# CITY OF ALBUQUERQUE

**RE: Defined Fitness at Unser Crossing**  
**8050 Central Ave SW**  
**Permanent C.O. – Not Accepted**  
**Engineer's Stamp Date: 01/23/19**  
**Engineer's Certification Date: 12/18/19**  
**Hydrology File: K10D045**

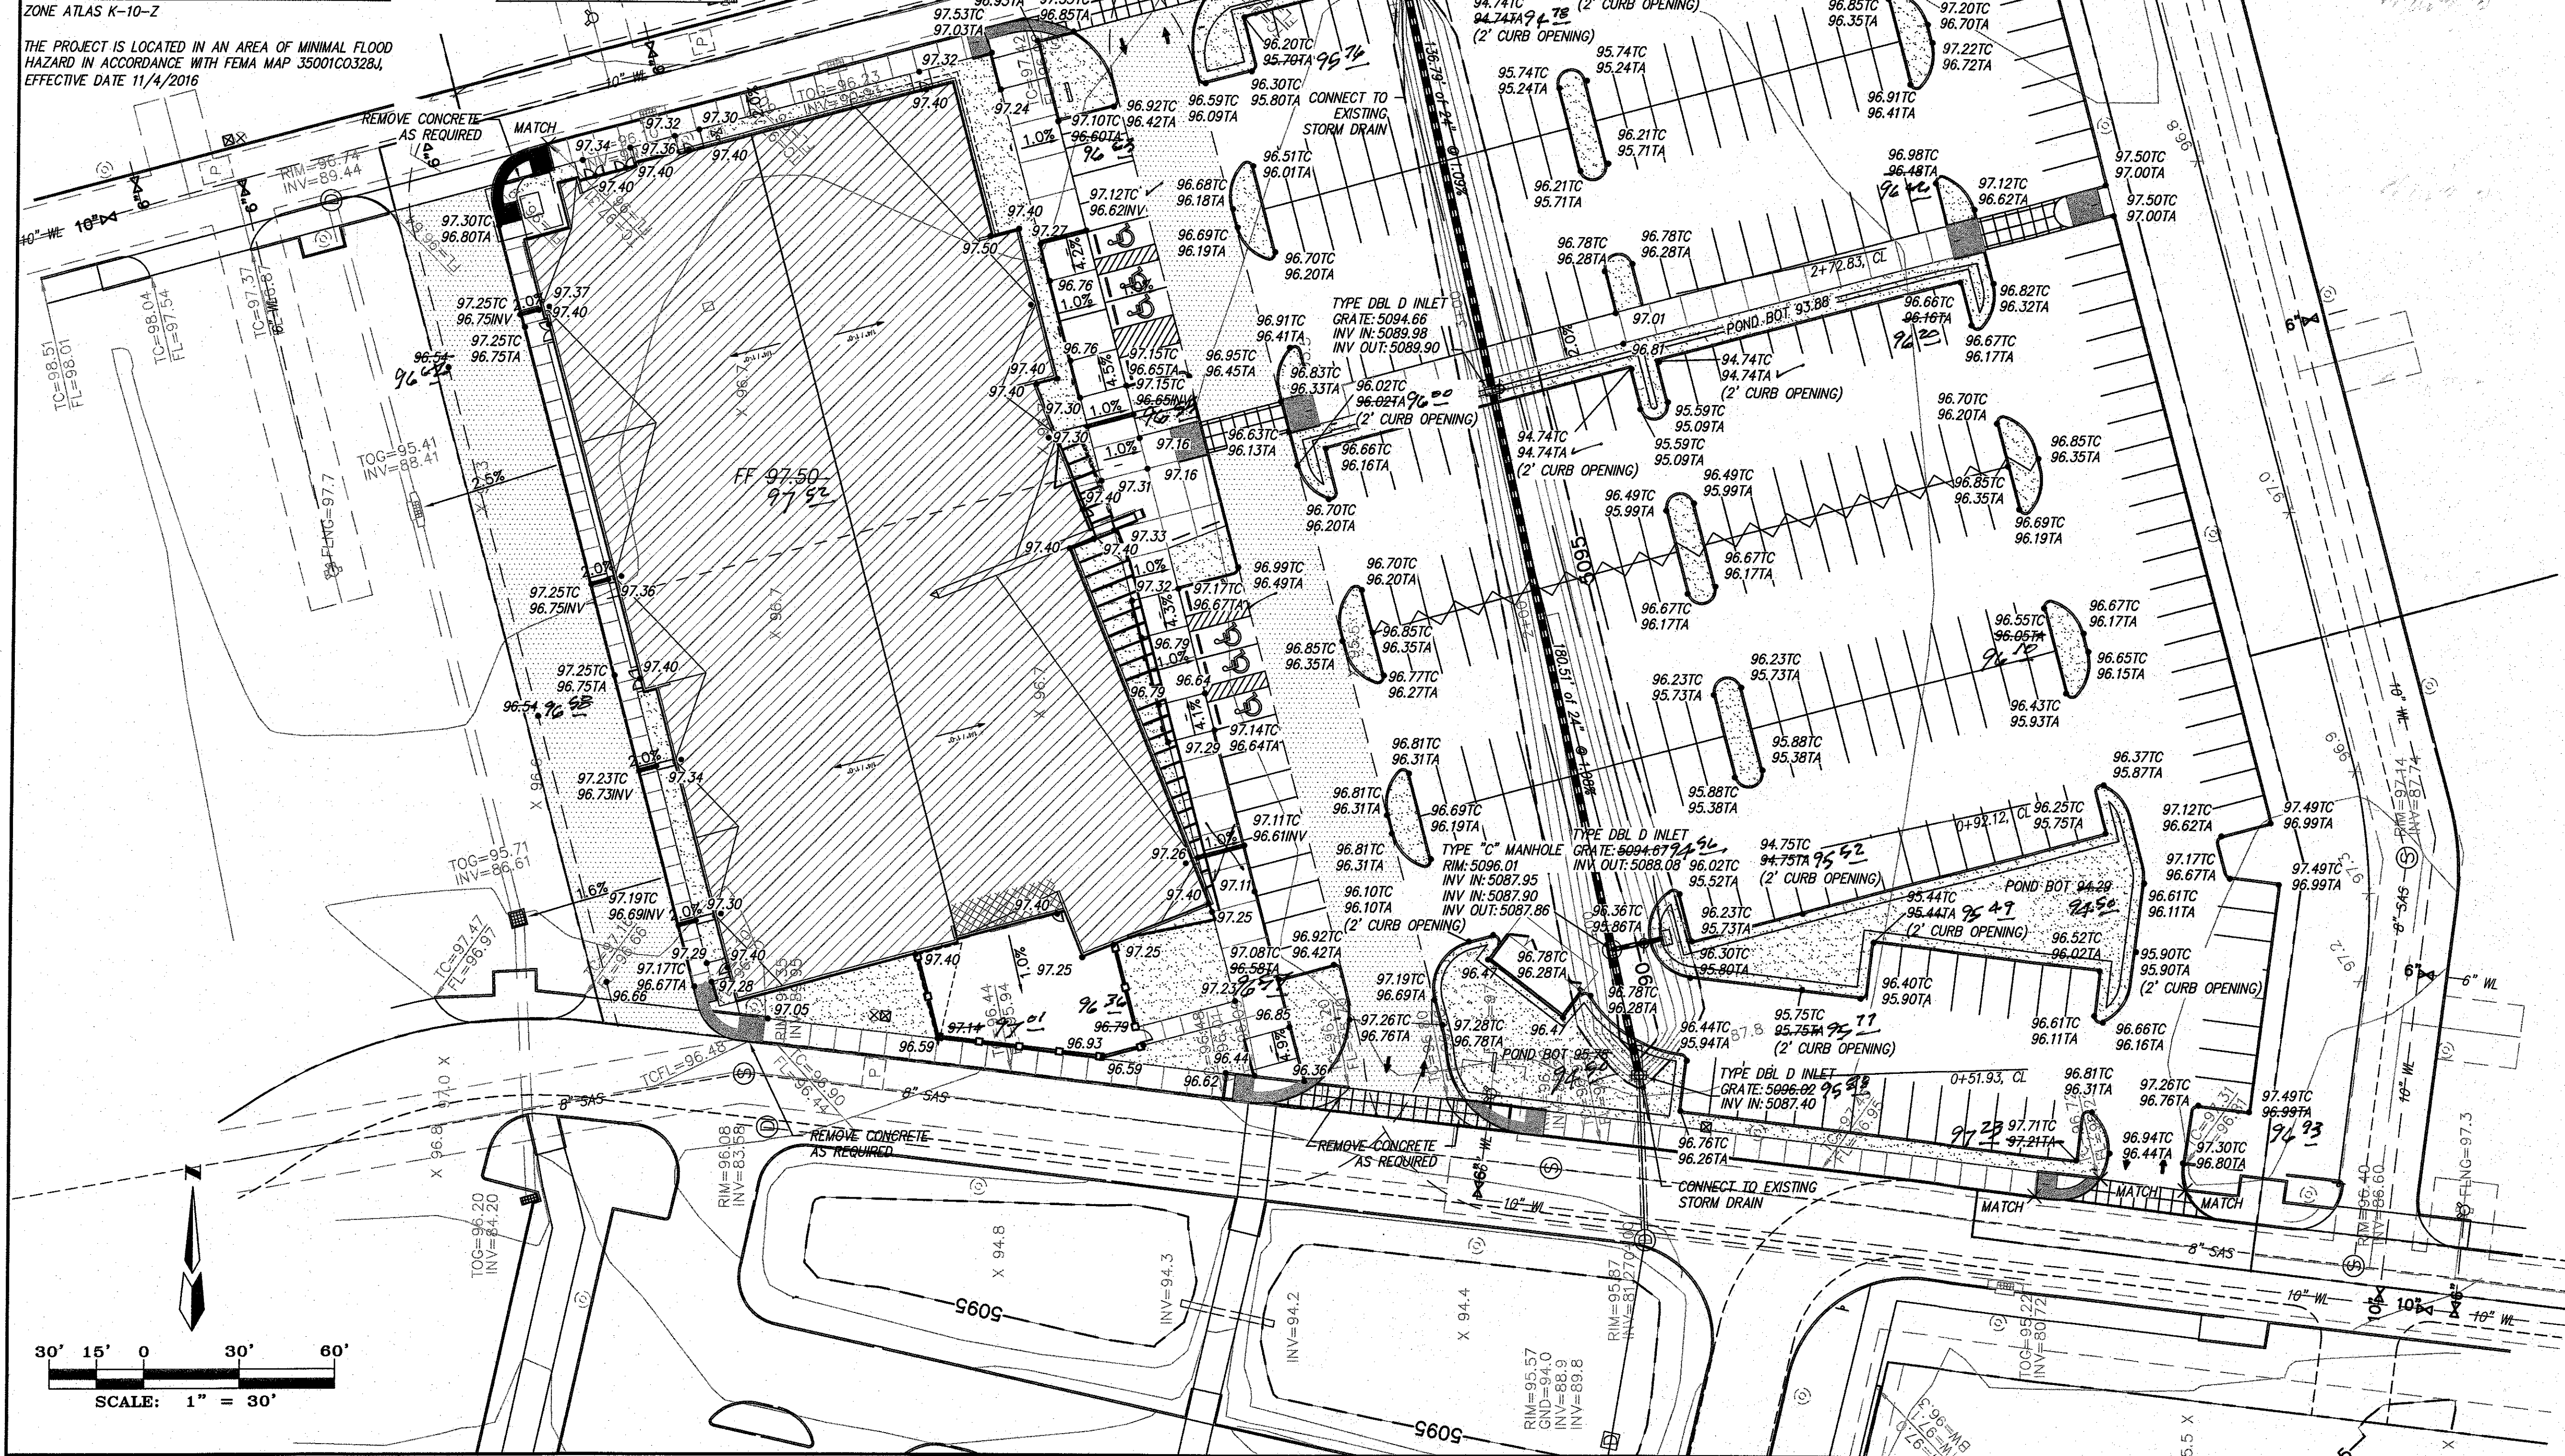
1. There is ponding within the ADA parking spaces. This needs to get fixed so that the whole area drains. See photos below.

2. The sections of the private sidewalk culverts need to be bolted down so that they do not get stolen. See photo below.

3. The inlet protection needs to be removed from the inlet. Also the irrigation line needs to be routed around the drainage pond. See photo below.
